Description: Change of use from private dwelling to 3 self-contained apartments. Two storey side extension and rear extensions. New dropped kerb to side/rear, new parking area and solar panels to roof.

Site Address: 2 Houghton Road, Thurnscoe, Rotherham, S63 0JT

This application seeks permission for a change of use from a private dwelling to 3 self-contained apartments, a two-storey side extension and rear extensions. In addition to a new dropped kerb to side/rear, new parking area and solar panels to roof.

PROPOSED SIDE ELEVATION,
NORTH-EAST FACING.

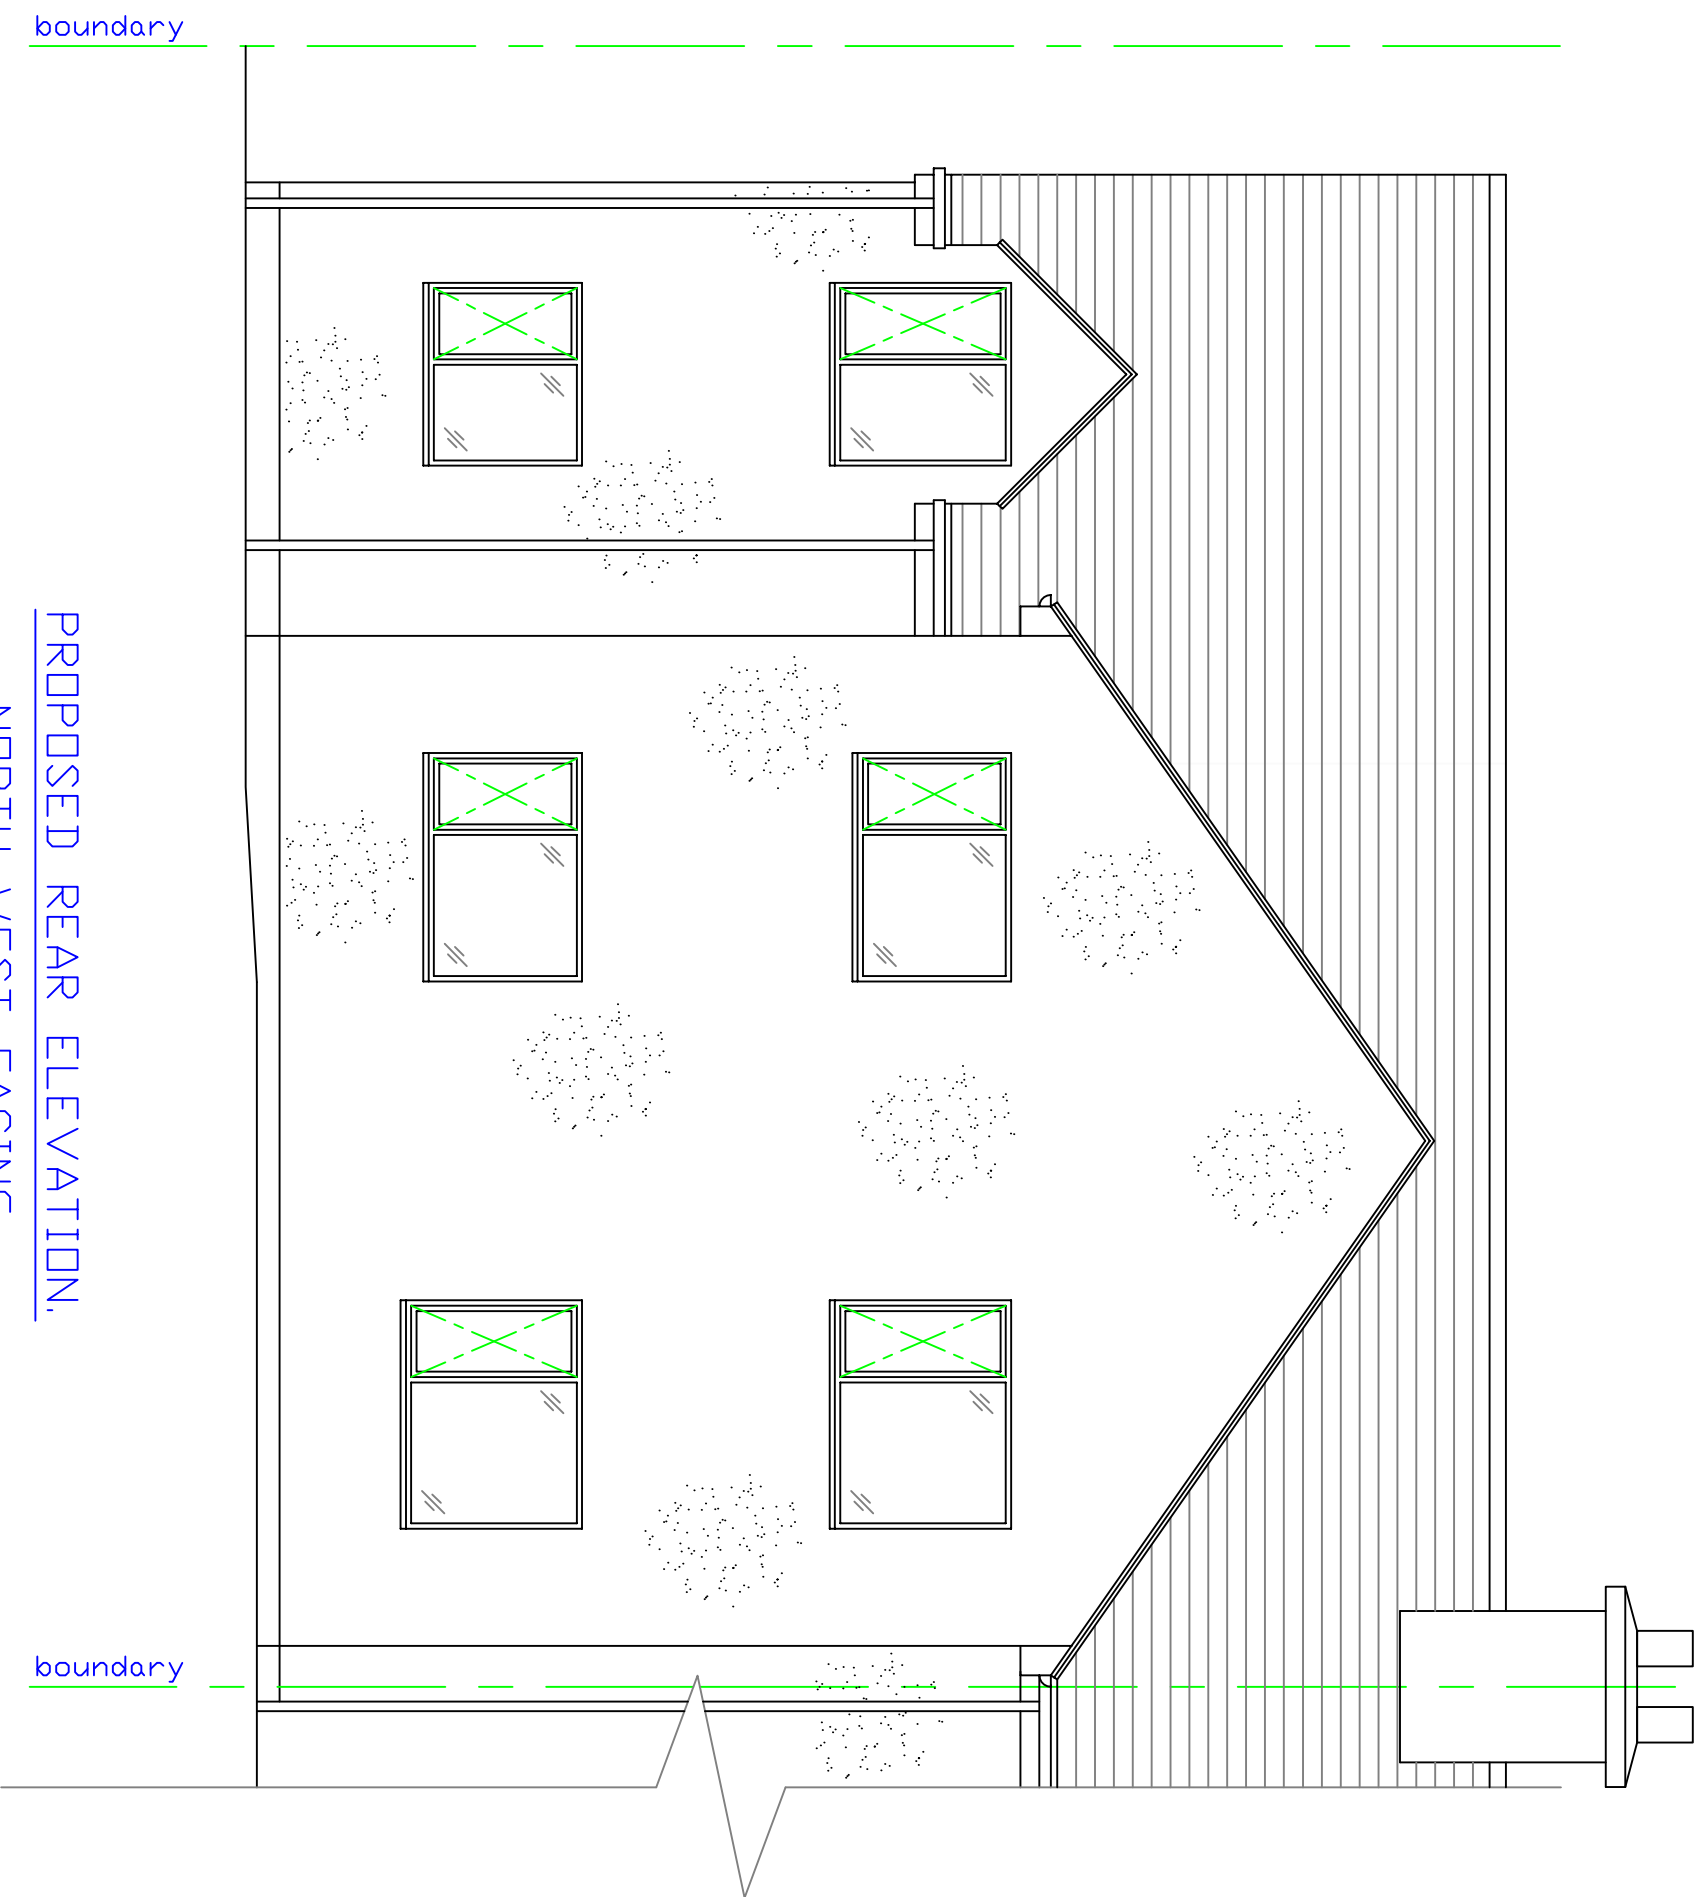
In this case, the two-storey side extension has a dual pitch roof alike the existing dwelling, however the extension fails to provide a setback from the front wall of the dwelling, from the side boundary or from the rear (which is necessary in the case of a corner plot). In this particular case, there is no adjacent dwelling to the east and as such a set in from the side boundary would not be a detriment as no terracing effect would be created to this elevation.

The dwelling is located on a corner plot and as such, the sideways projection of the extension should not exceed more than half the width of the gap between the side elevation of the original dwelling and the side boundary. The distance between the side elevation and boundary is approximately 4.9m and as such the extension would be permitted to be 2.45m in width. The extension measures 4.32m and as such does not conform to this standard.

In this case, the extension does not appear subservient and instead appears to dominate the dwelling, providing no setbacks in any direction. Therefore, the extension would not only be detrimental to the subject dwelling but to the other semi within the pair of dwellings and surrounding street scene due to the dwelling's location on the corner plot which exacerbates the extension.

The rear extension would project 3m from the rear wall of the dwelling and would have a gable roof alike the existing roof of the dwelling. The extension would conform with the SPD in terms of its depth, however it is considered that the rear extension would appear out of character in the row of dwellings and in the pair of semis and additionally would be highly visible from the John Street/Houghton Road junction, exacerbated by the dwellings location on the corner plot.

The proposed extension is to intersect the 45-degree quadrant by approximately 1.17 meters and it is considered that the proximity of the extension to the party boundary and the substantial expanse of brick work will limit levels of outlook and have an overbearing impact on the adjoining property to the detriment of residential amenity which would conflict with Local Plan Policy D1.
